<b>Application Ref:</b>	3/2021/0400	 <b>Ribble Valley Borough Council</b> <a href="http://www.ribblevalley.gov.uk">www.ribblevalley.gov.uk</a>	
<b>Date Inspected:</b>	Feb 21 on previous application		
<b>Officer:</b>	LE		
<b>DELEGATED ITEM FILE REPORT:</b>		<b>Decision</b>	<b>APPROVE</b>

<b>Development Description:</b>	Proposed garage extension and partial conversion to form habitable floorspace. Raising existing garage roof to form first floor bedroom over, with rear dormer window. Resubmission of 3/2020/1074.
<b>Site Address/Location:</b>	Overdale Dilworth Lane Longridge PR3 3ST

**JM-0216**  
**PROPOSED**  
**SITE PLAN**

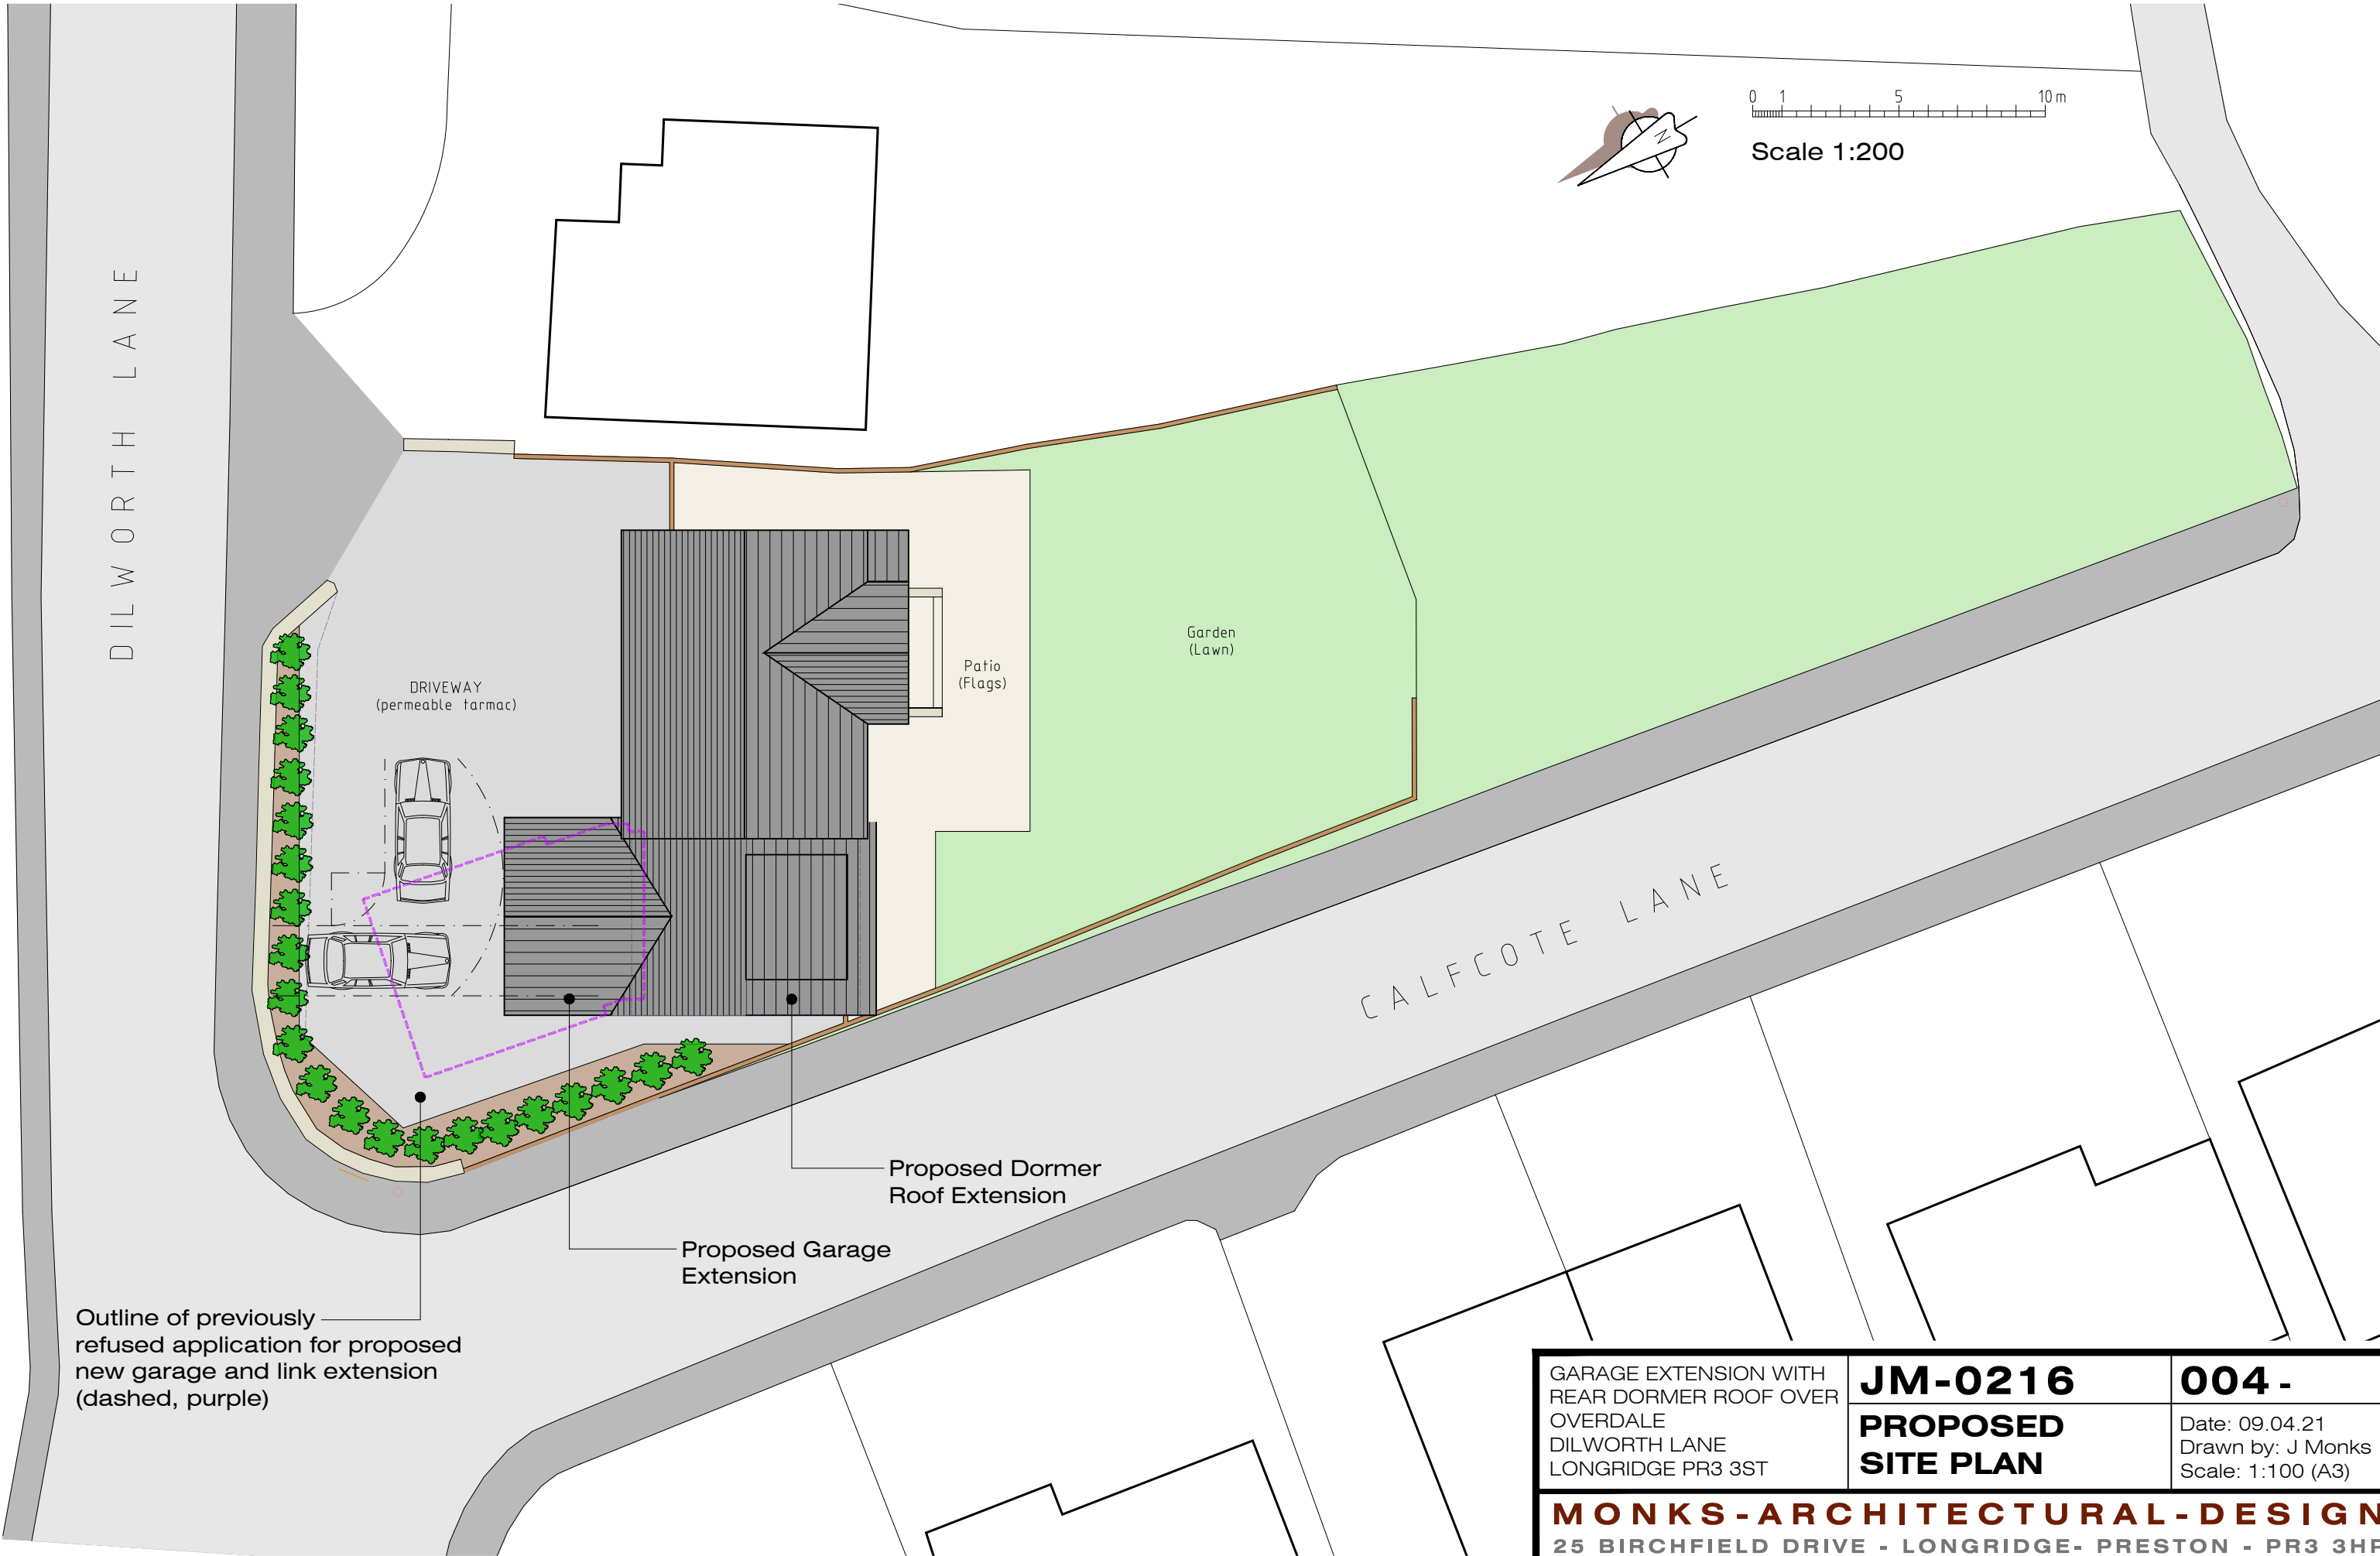
The revised scheme proposes a more modest extension to the front of the existing garage which will bring the principle elevation of this part of the house forward by 4 metres and it will be no closer to the side boundary given that this is splayed and the distance from the side of the dwelling increases from front to rear. The front elevation of the extended garage will be roughly in line with the front of the adjacent dwellings garage (number 19) and there will be a distance of approx. 8 metres to the front boundary. Additional living accommodation will be provided internally and the roof lifted by approx. 1.5 metres to allow a loft conversion and rear dormer.

Dilworth Lane and Calfcote Lane are residential streets with assumed 30mph speed limit and so a visibility splay of 2.4 x 70m should be achieved and the proposal would not encroach on that.

Whilst it would introduce built form closer to the road than the current situation it is not considered that it would obstruct visibility for vehicles waiting at the junction on Calfcote Lane as Dilworth Lane is a fairly straight road with good visibility.

**JM-0216**  
**PROPOSED**  
**ELEVATIONS-1**

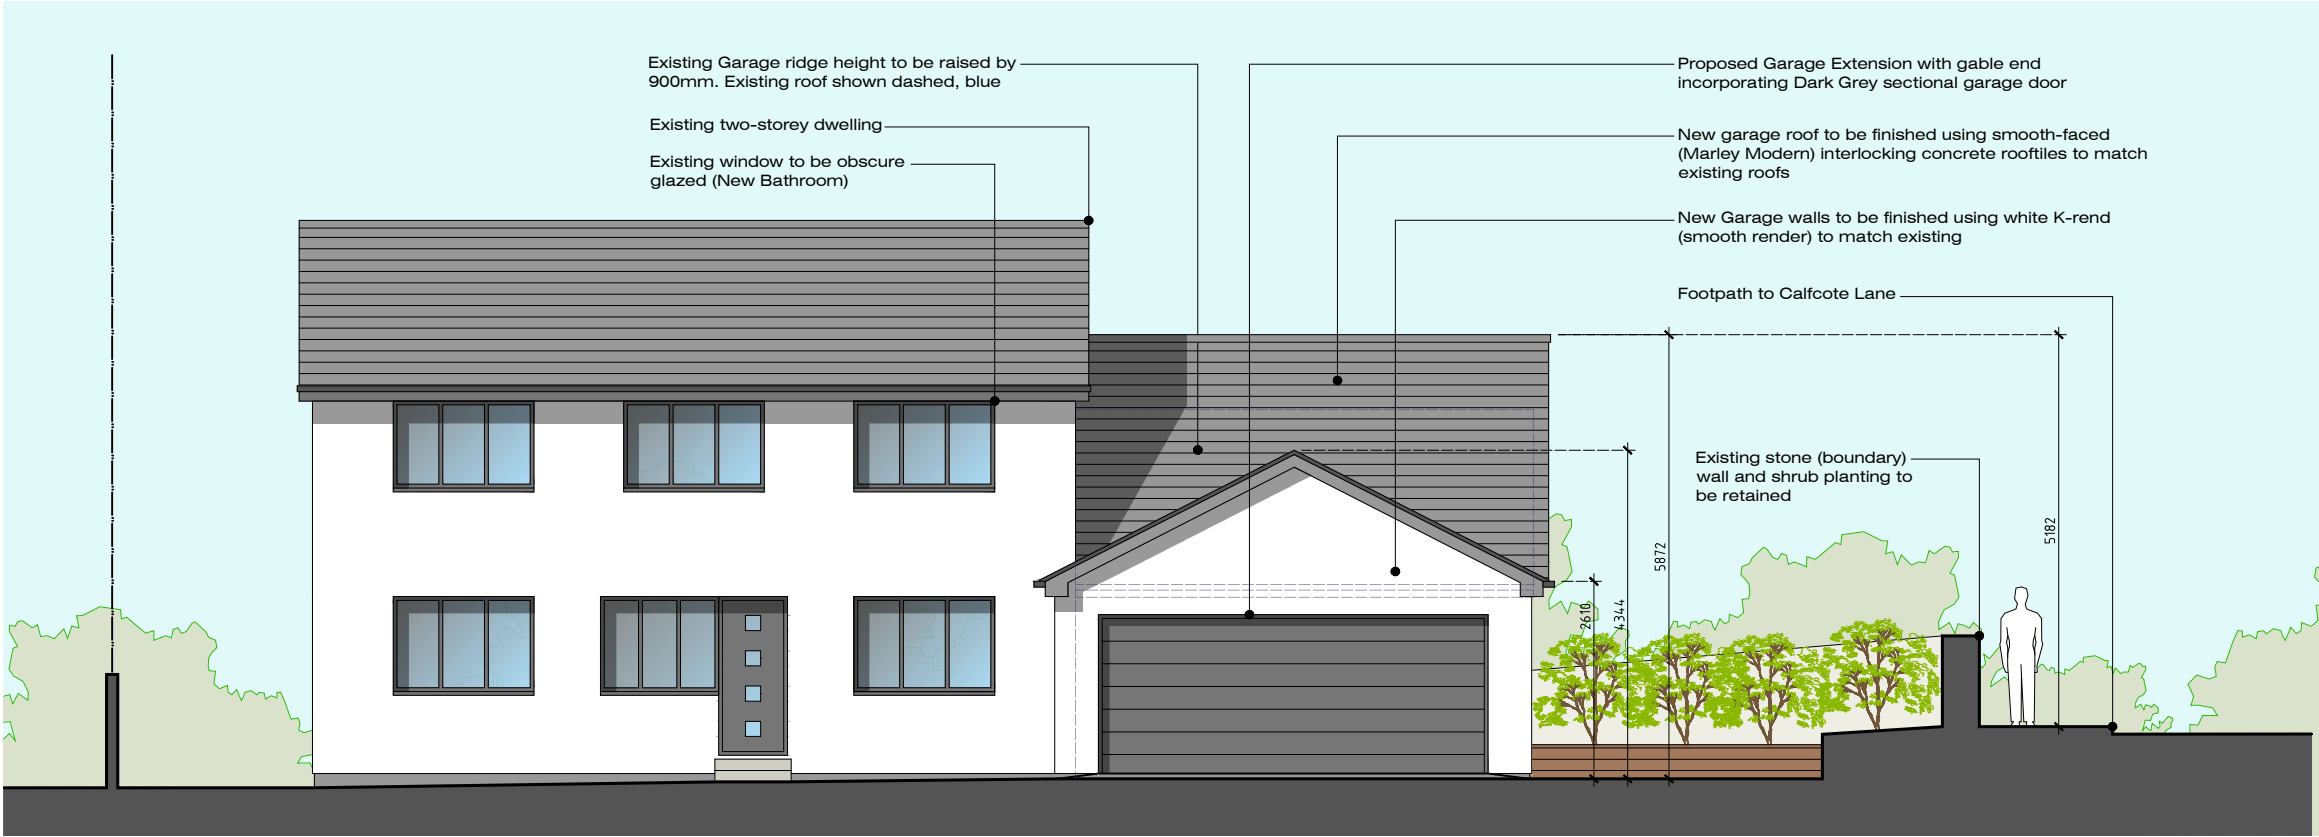
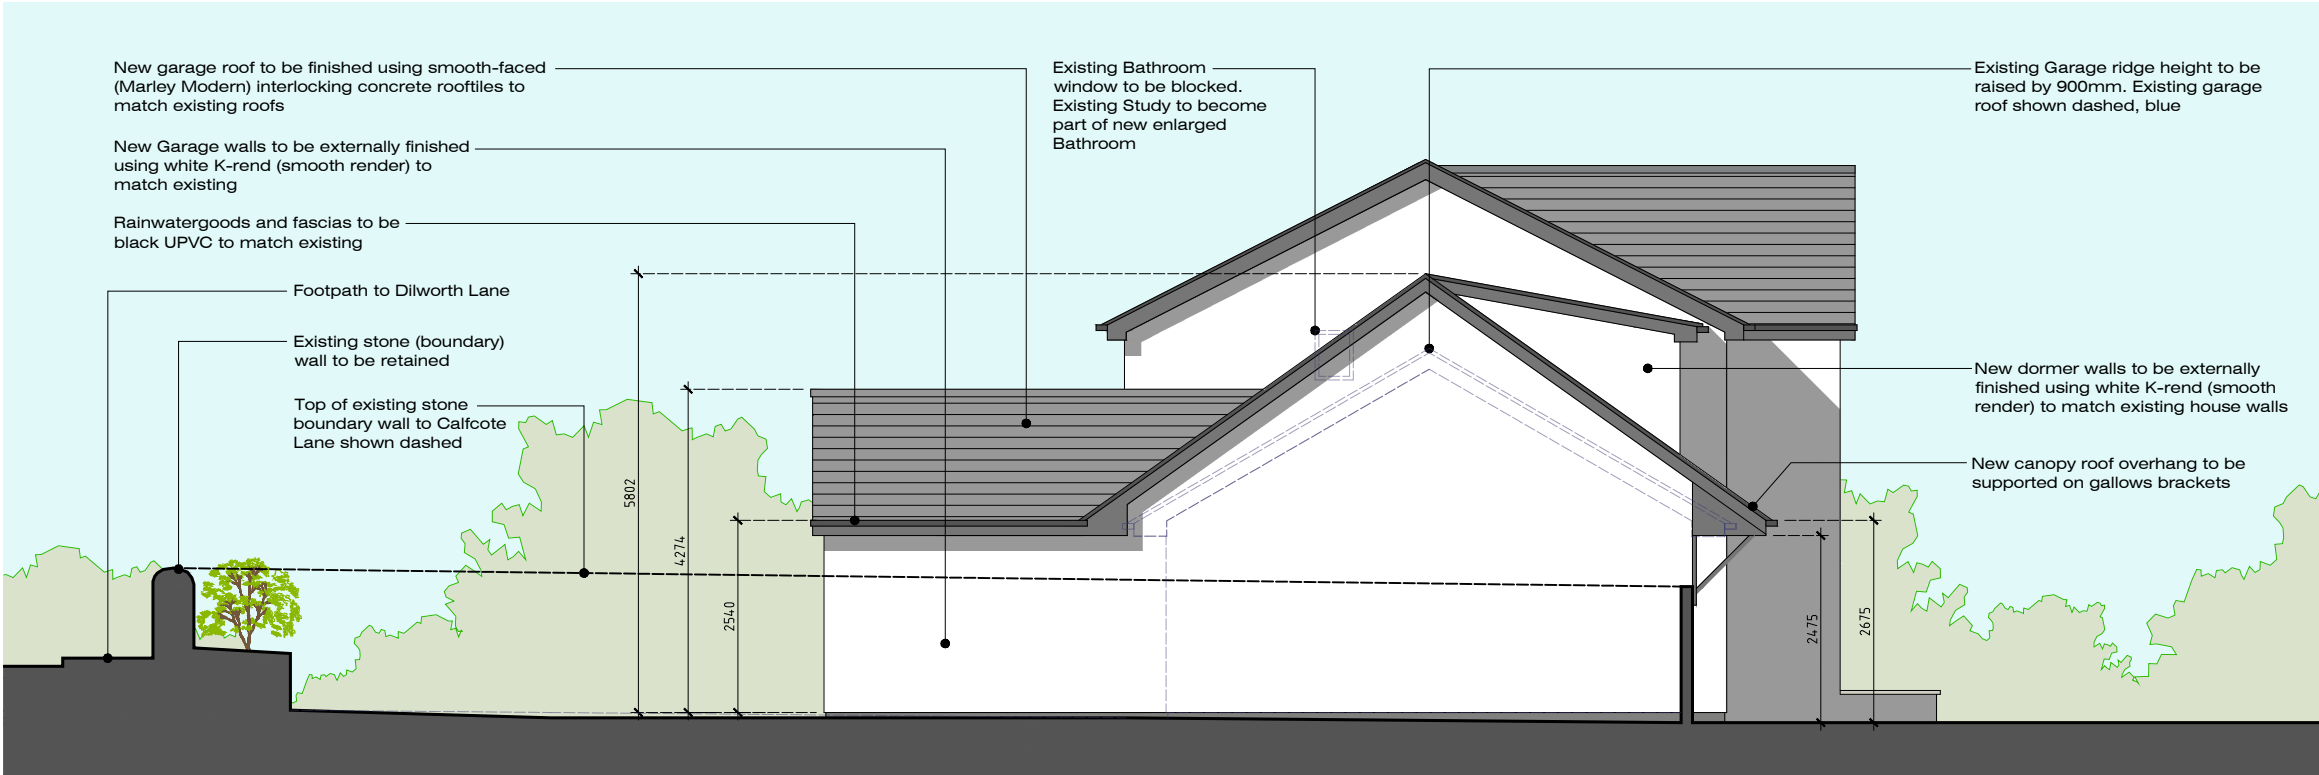
It is considered that the revised scheme presents a much more sympathetic proposal which will not be an over dominant feature in the street scene and addresses the previous concerns in terms of visual impact.

GARAGE EXTENSION WITH REAR DORMER ROOF OVER OVERDALE DILWORTH LANE LONGRIDGE PR3 3ST	<b>JM-0216</b>	<b>007 -</b>
	<b>PROPOSED ELEVATIONS-2</b>	Date: 12.04.21 Drawn by: J Monks Scale: 1:100 (A3)
<b>MONKS-ARCHITECTURAL-DESIGN</b> 25 BIRCHFIELD DRIVE - LONGRIDGE- PRESTON - PR3 3HP

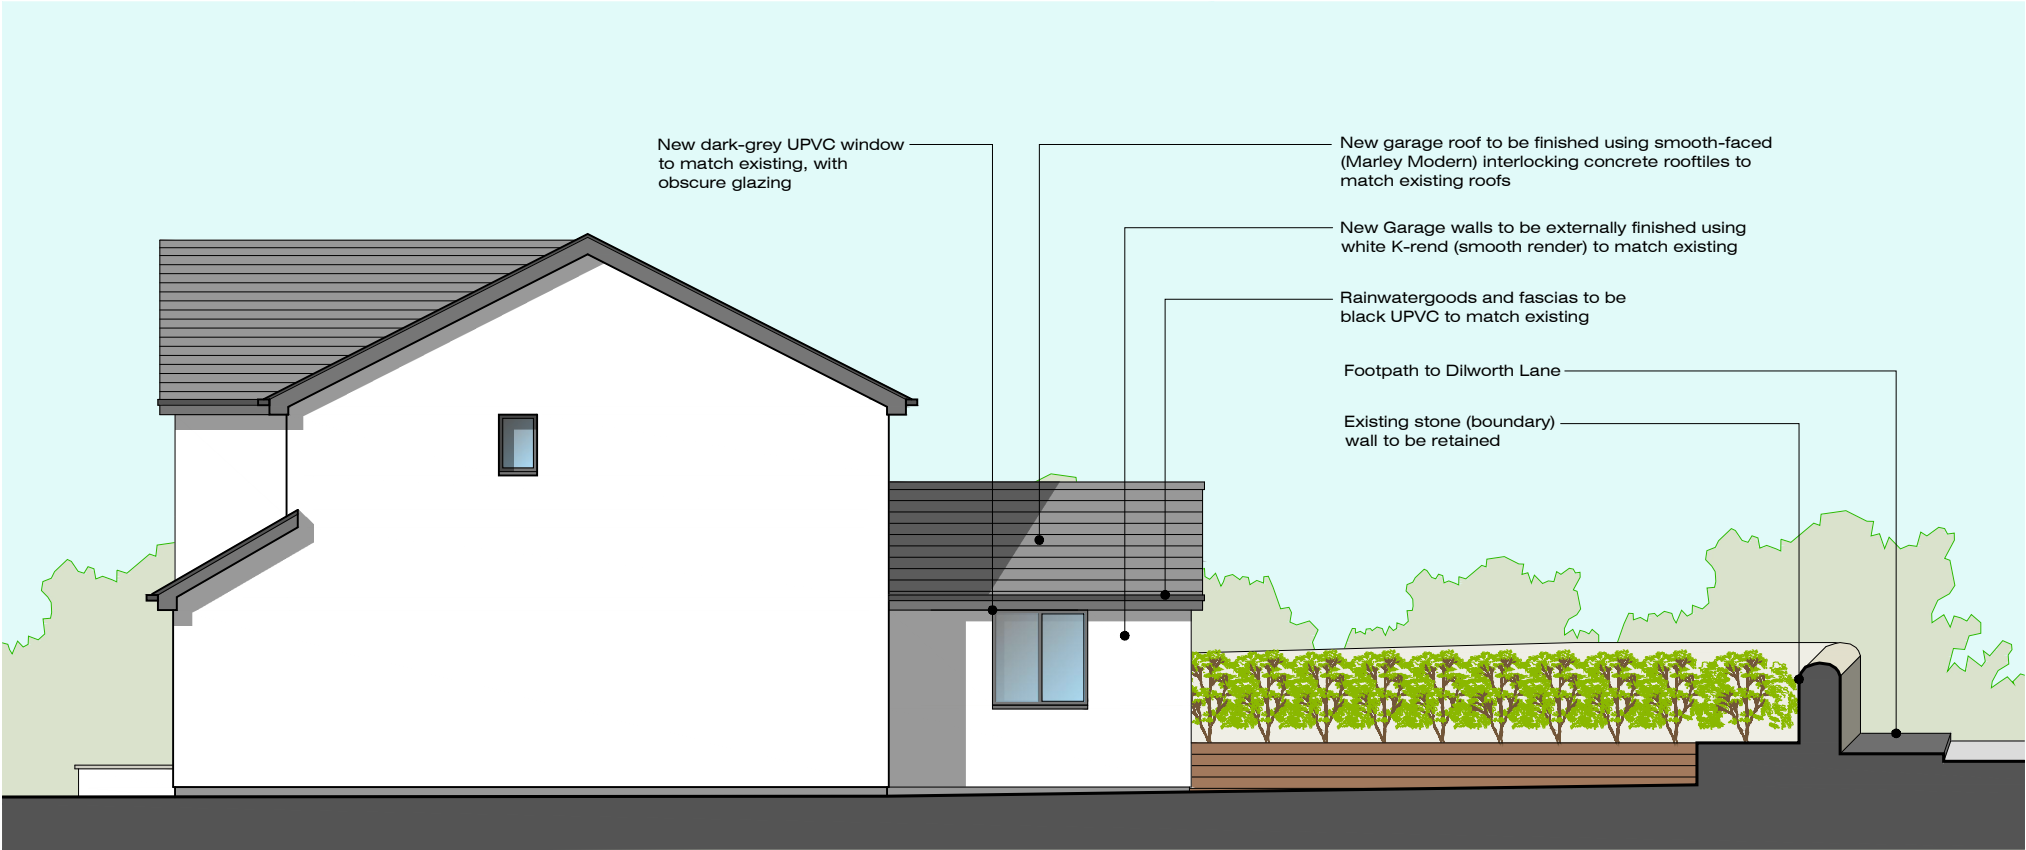
The proposed extensions are located to the front of the property and the rear dormer will overlook the properties own garden. It is acknowledged that permission has been granted for a new dwelling to the rear but the dormer will not introduce any new windows that are closer than those existing on the rear elevation.
